**Application: SSI 7485**

I write regarding the proposed modification to M4-M5 Link, Mod 2 The Crescent overpass and changes to pedestrian infrastructure in North Annandale, Rozelle and Rozelle Bay Foreshore area.

Figure 4-2 Pedestrian and cyclist bridge infrastructure options

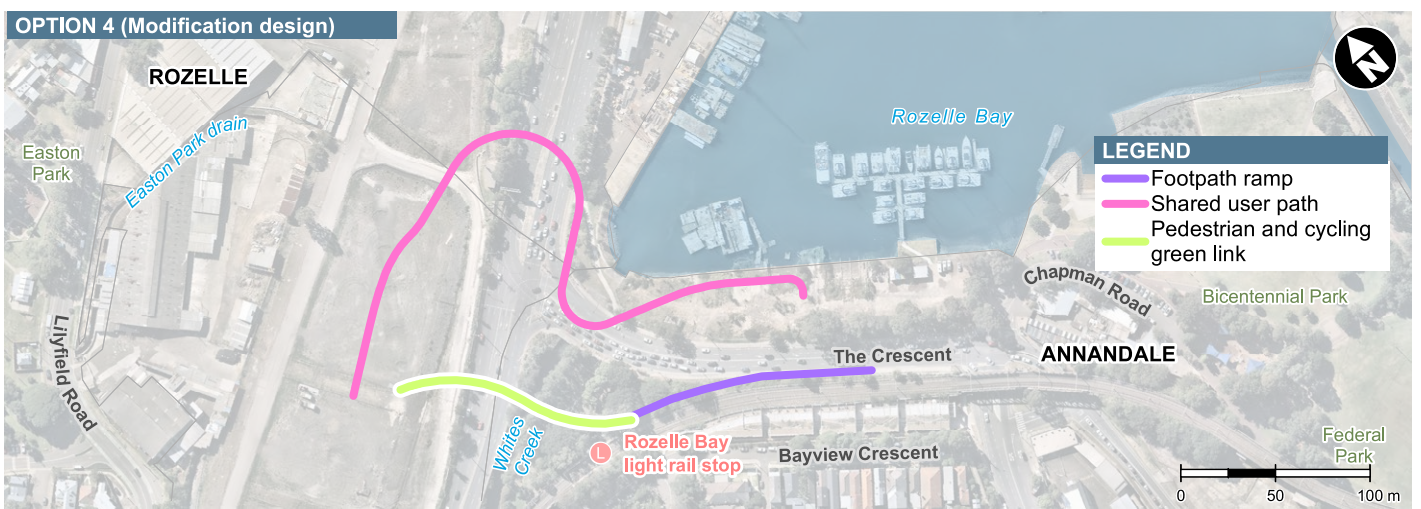
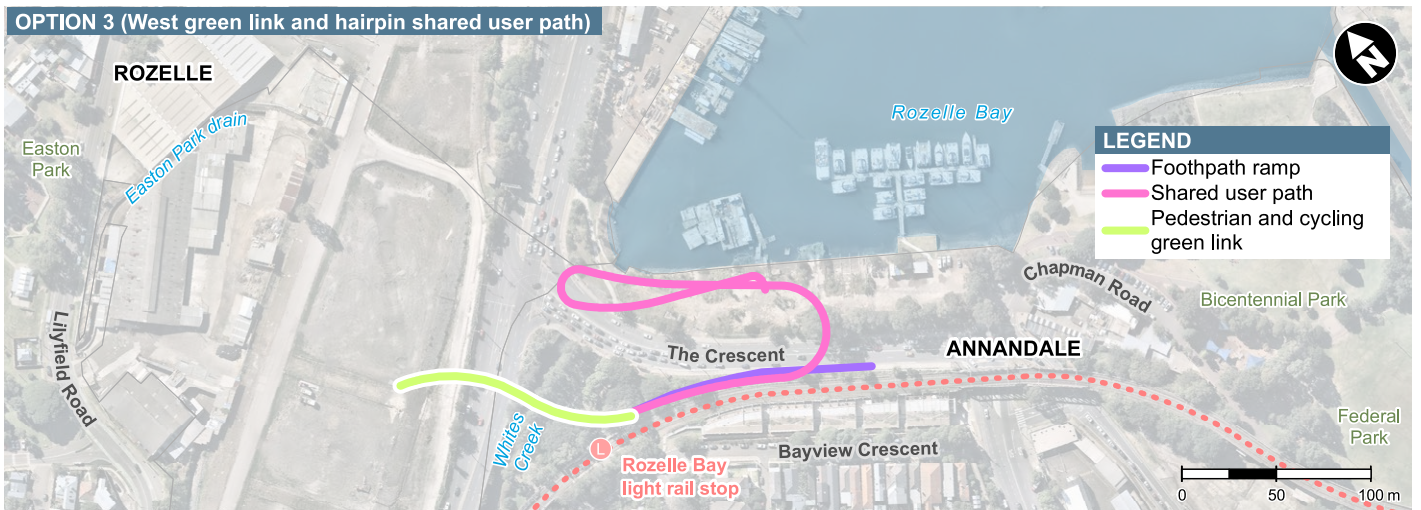
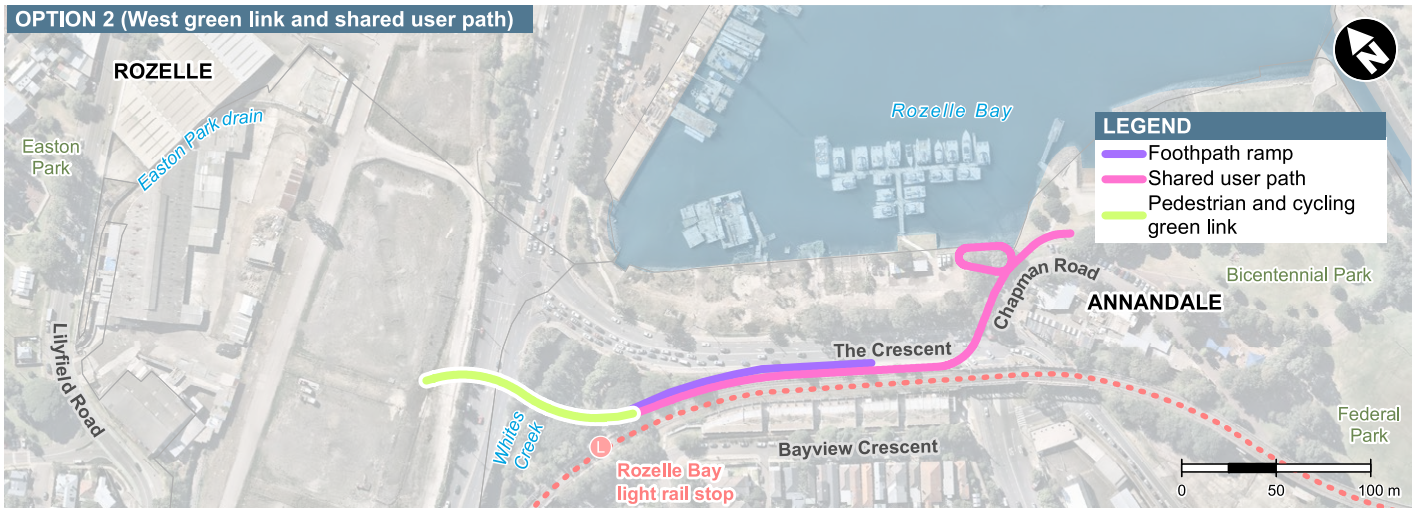
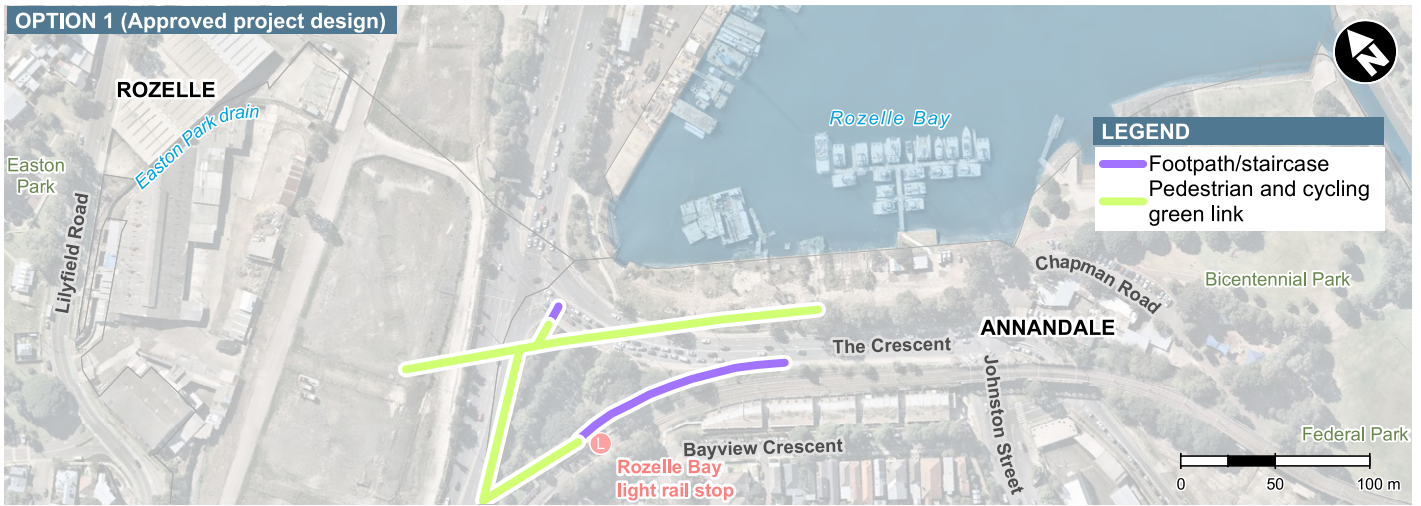
I request RMS work with the community to explore alternate design options to the proposed new car overpass design and the changed pedestrian and cyclist links. I am seeking the reinstatement of the safe, direct access from the approved EIS GreenLink to create a continuous green open space connection from the Rozelle Rail yards and Annandale to the foreshore. The GreenLink was more than just a walk way - it put people central to the design, maximising safety, and providing much needed accessible open space for the community now and into the future Bays Precinct design.

- The significantly reduced safety and increased risk for pedestrians and cyclists with removed access over The Crescent to Bicentennial Park and the increased traffic along Johnson Street.
- Being required to cross five sets of pedestrian lights at The Crescent as my option to reach the foreshore from Annandale or from Rozelle Bay light rail stop.
- Removal of direct active links to the foreshore, cutting the community off from the area and the proposed revitalisation of the entire Bays Precinct, including linking the Light Rail and Bus stops to a Ferry wharf and Metro station.
- Urban and landscape design that is being built before a finalised Masterplan for the area.
- Traffic changes that limit movements around the suburb and create further congestion in the local streets of Annandale, Forest Lodge, Glebe, Lilyfield and Rozelle with no planning to deal with these.

- Reinstatement of the GreenLink connecting communities and green open space from Rozelle to Bicentennial Park
- Relocate and design pedestrian and cyclist connections that are continuous, safe and direct.
- Design the modification infrastructure and active links in response to the character of the suburbs, the location of the foreshore and its potential future development.
- Provide pedestrian and cyclist paths that maximise people safety and do not force them onto busier streets, unsafe concrete plazas and caged walkways.
- Integrate active and direct connections to all active transport - including the future Metro West and Foreshore Ferry Wharf
